**From:** [alan.story@hertfordshire.gov.uk](mailto:alan.story@hertfordshire.gov.uk)  
**To:** [Planning](#)  
**Subject:** Planning application 6/2018/2387/MAJ - 37 Broadwater Road  
**Date:** 22 October 2018 11:59:40

**Response to Planning application from Hertfordshire County Council (T and CP GDP Order 2015)**

**District ref:** 6/2018/2387/MAJ

Construction of new build of 22 x 2 Bedroom and 2 x 3 Bedroom residential apartments with balconies and a roof garden. Layout of 26 car parking spaces, cycle parking, refuse store, internal access routes, landscaping and supporting infrastructure. All as application approval 6-2016-2497-MAJ

Scale:	Job protect:	Drawn:	Checked:
1:100@A1	N/B	N/R	
Date:	Project no.	Drawing no.	Revision
09/10/2018	1583	206-1	C

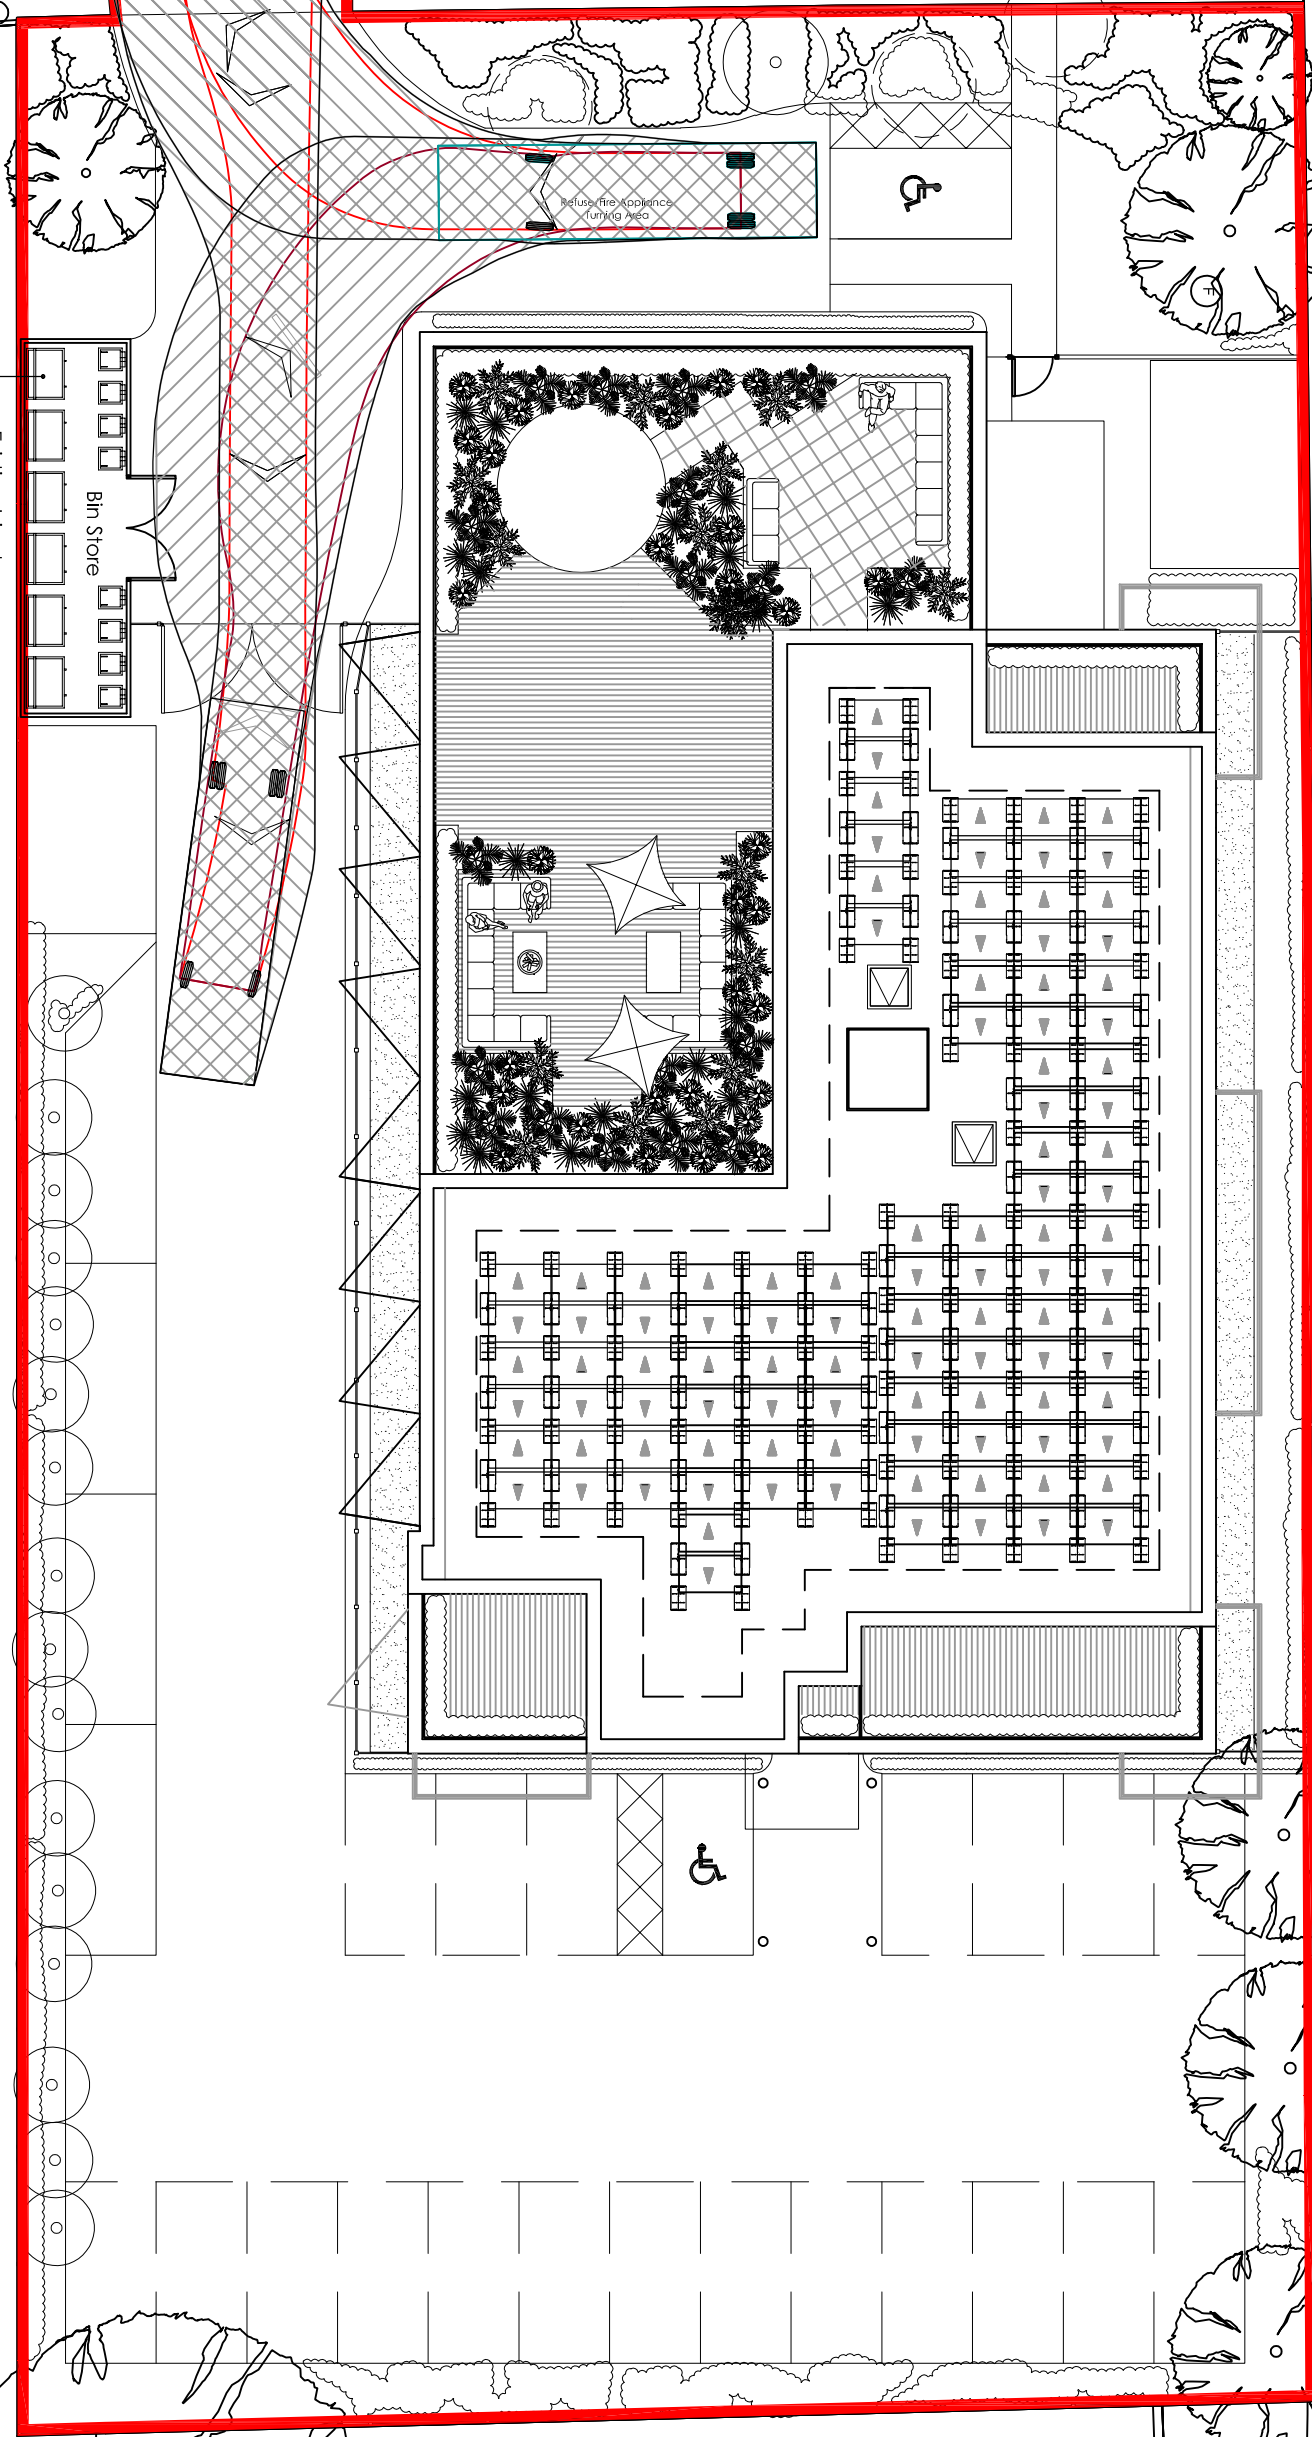
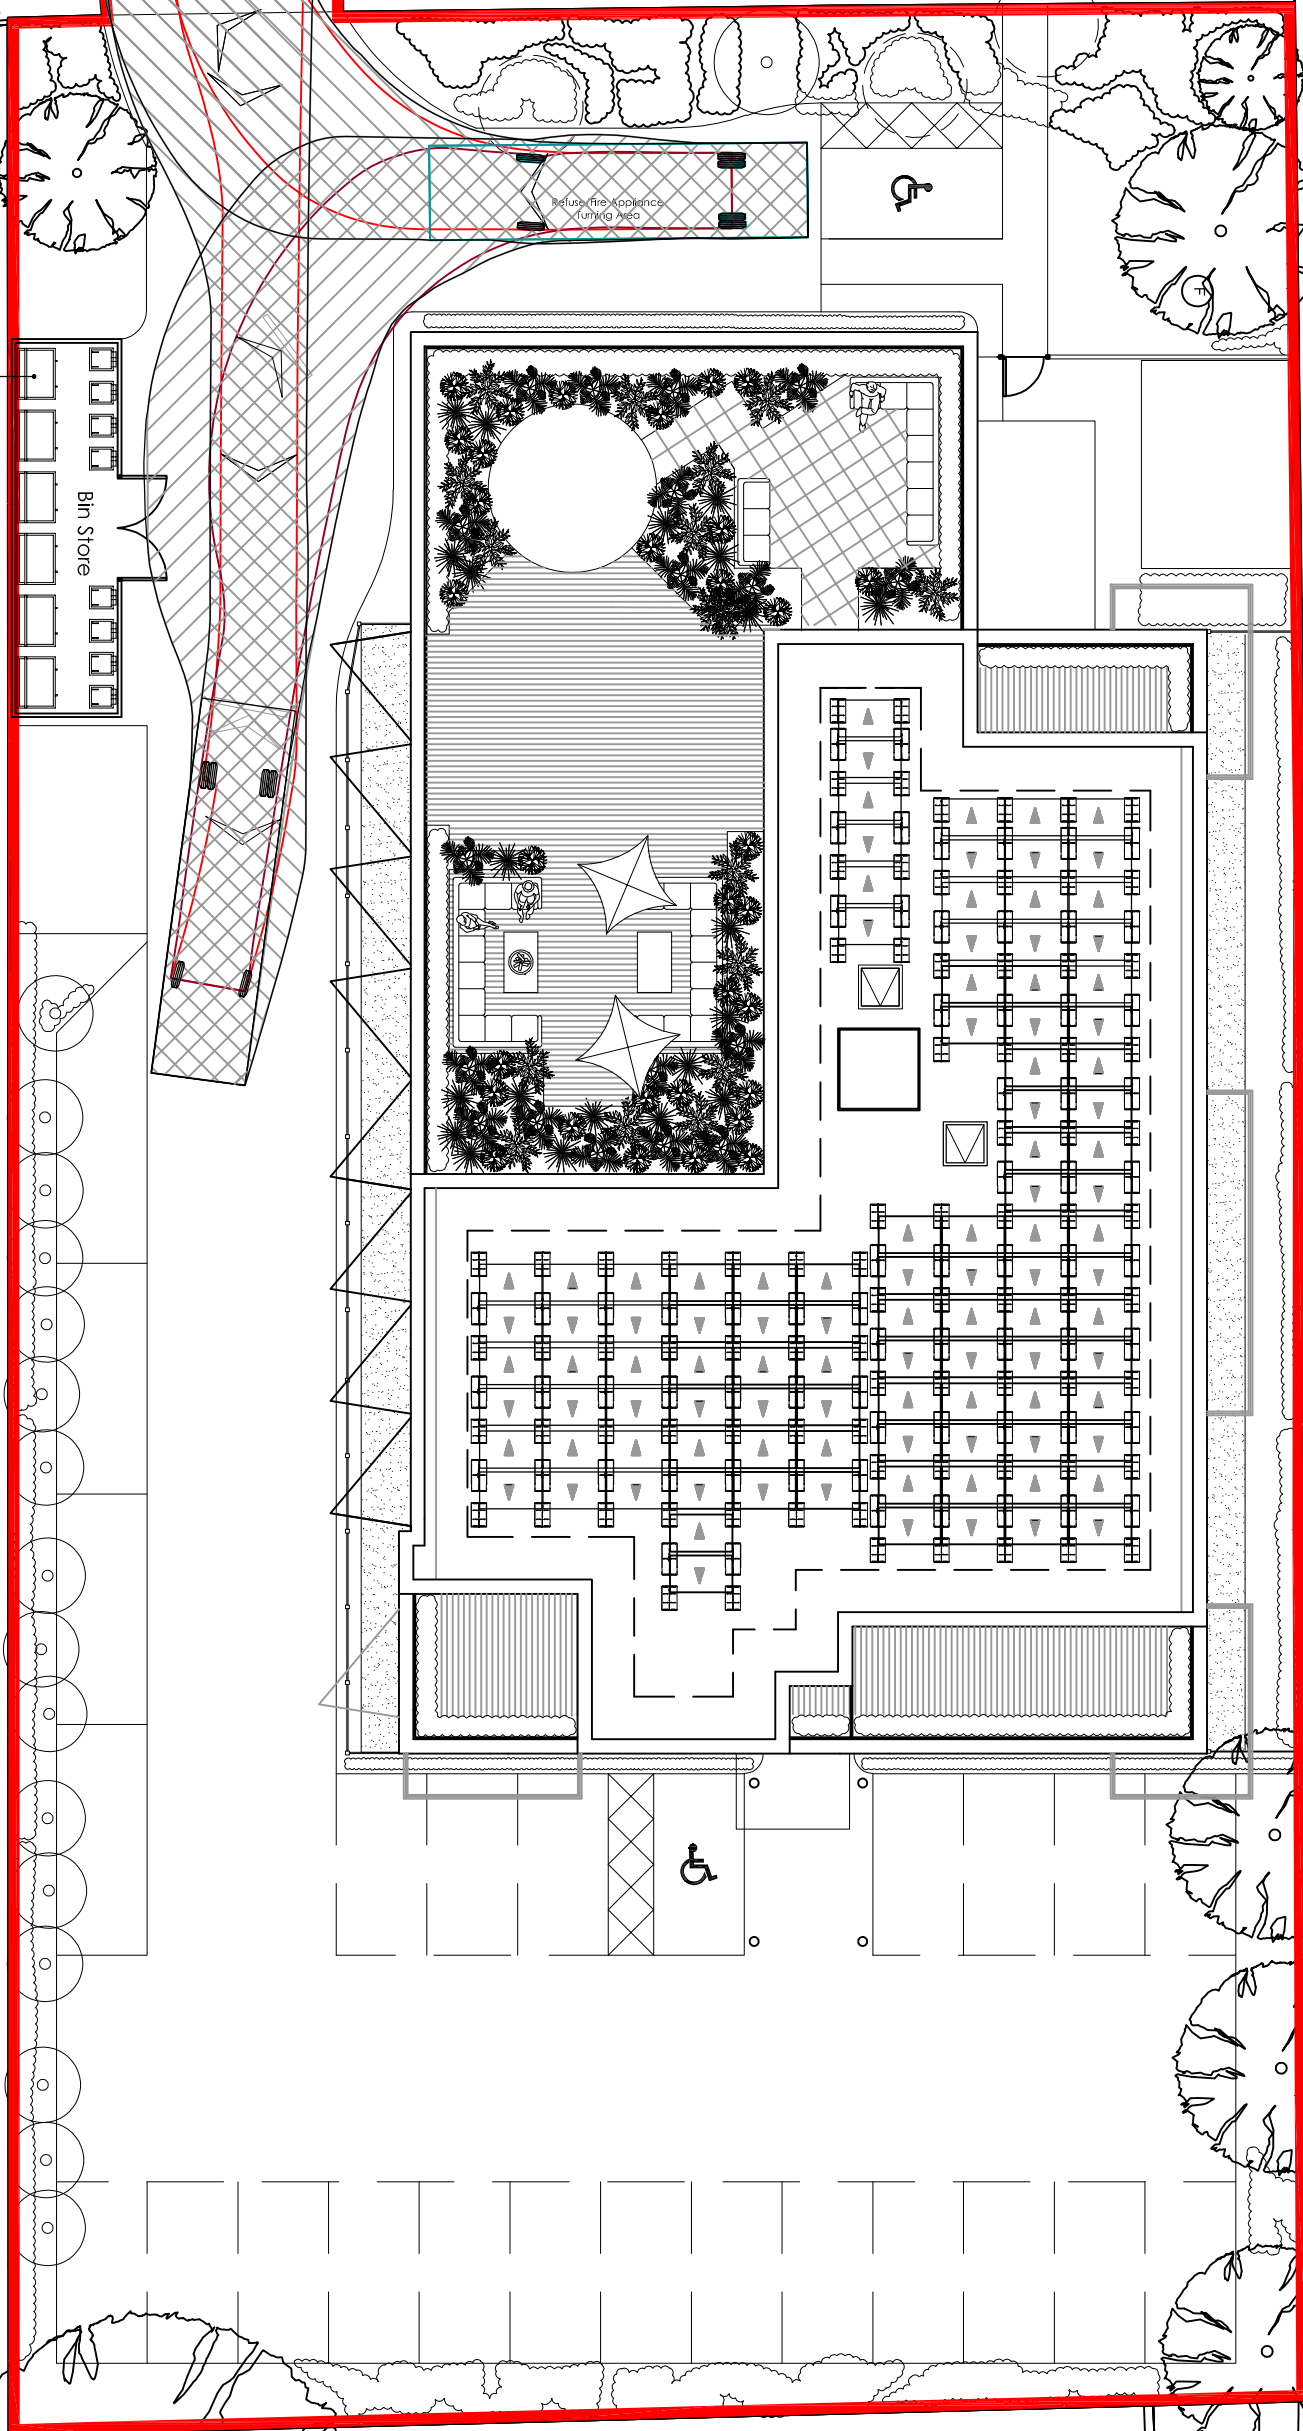
A turning head is provided in the front, for refuse / fire appliance, but is not tracked. Irrespective of such information, any turning would require the gates shown to be open, and this cannot be relied upon. A condition solely requiring the turning to be demonstrated would be insufficient, as it shall also require control over the gate by either site operator, or refuse staff. Gated access may also restrict access to bins. These matters shall potentially force large vehicles to reverse from the site contrary to the hierarchy of roads and prejudicial to pedestrian / vehicular safety. Gated access may also restrict emergency vehicle access to within all necessary parts of the site.
